4670 LIMESTONE RD
OWNERS: Thomas and Lesa Owens

PROPOSED USE SITE PLAN 1/2

Markup Summary

PROPOSED USE SITE PLAN 3/13
(NOT TO SCALE)

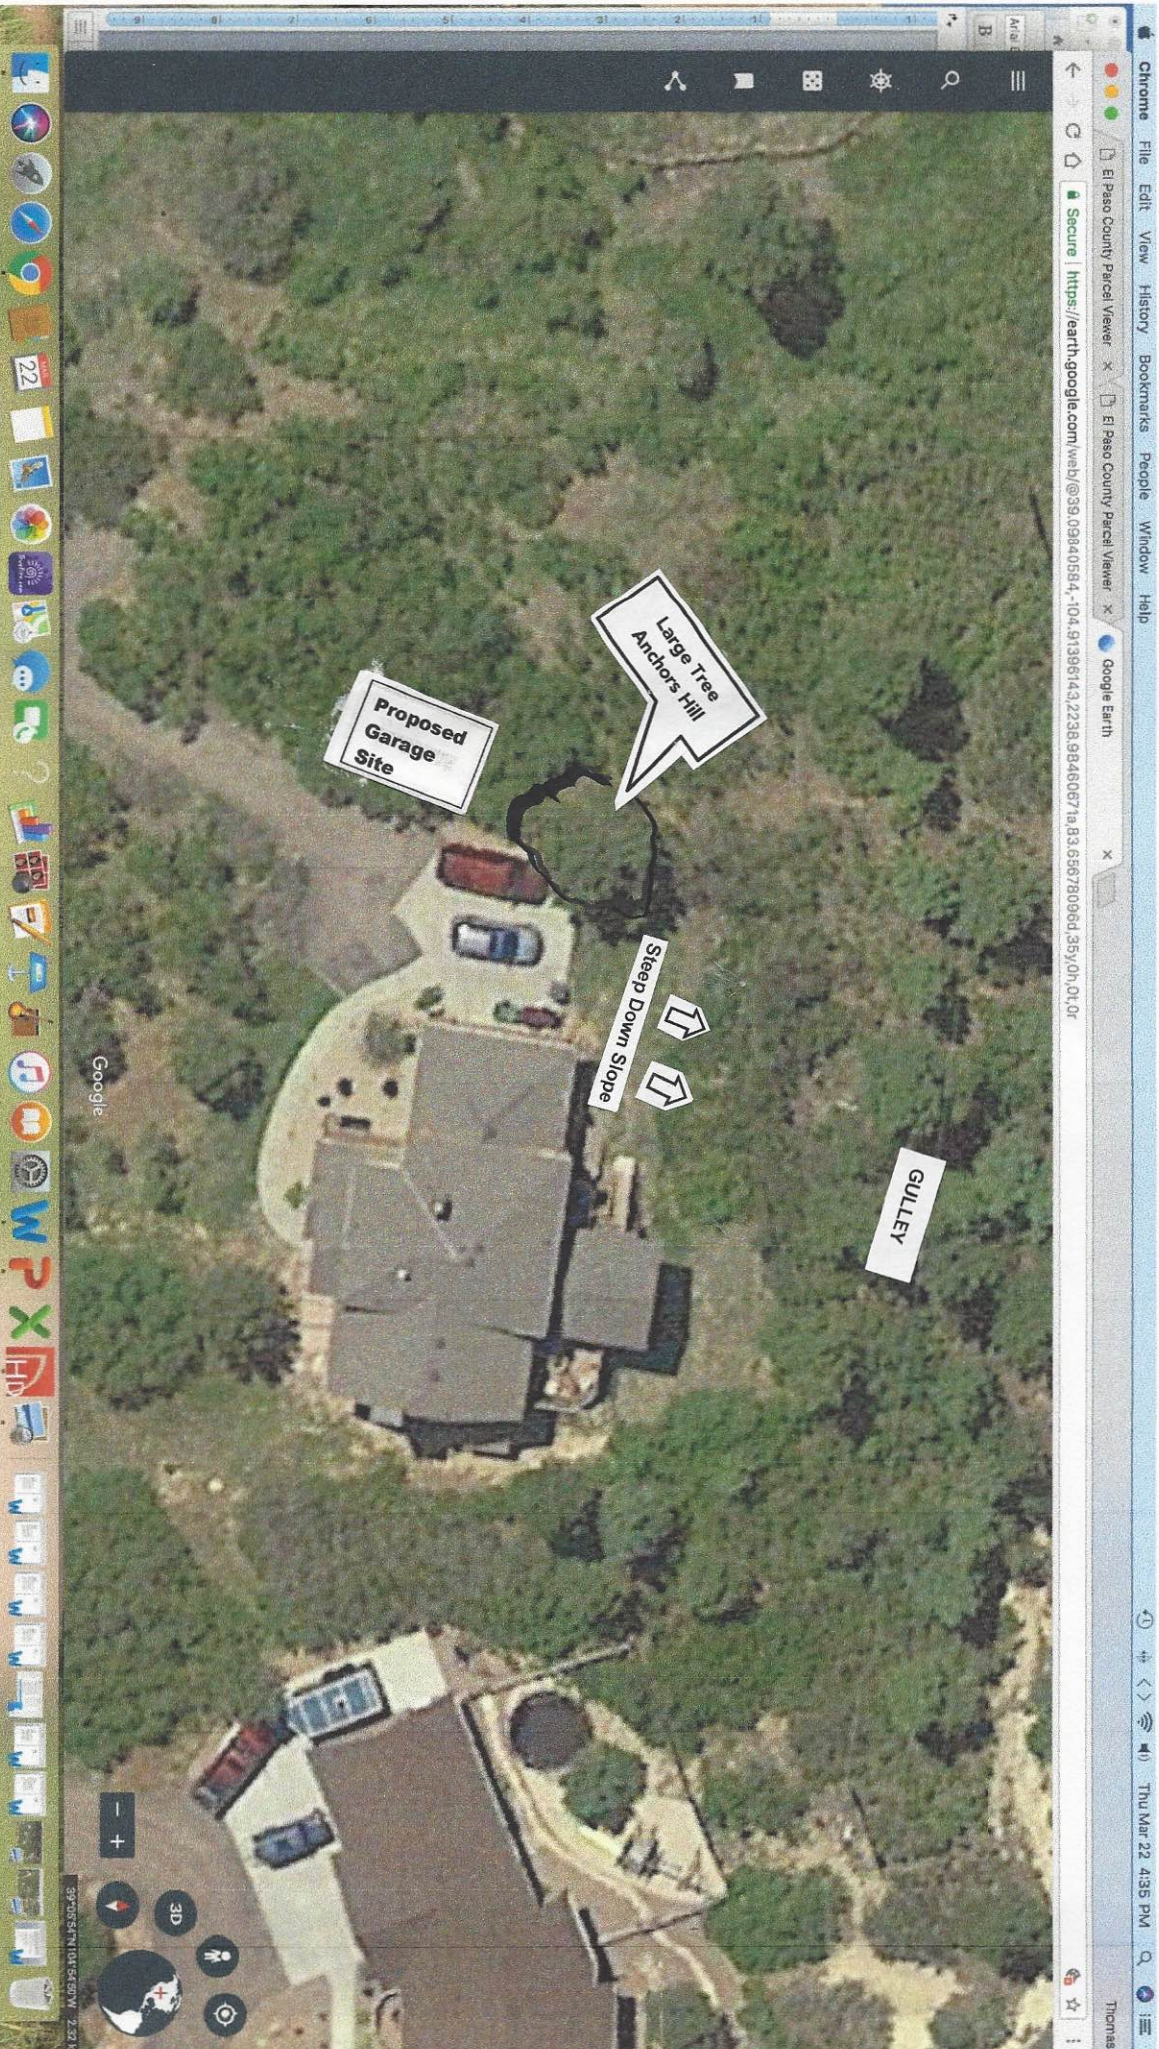
Provide name
and address for
adjacent
properties

Driveway access permit is
required to be submitted
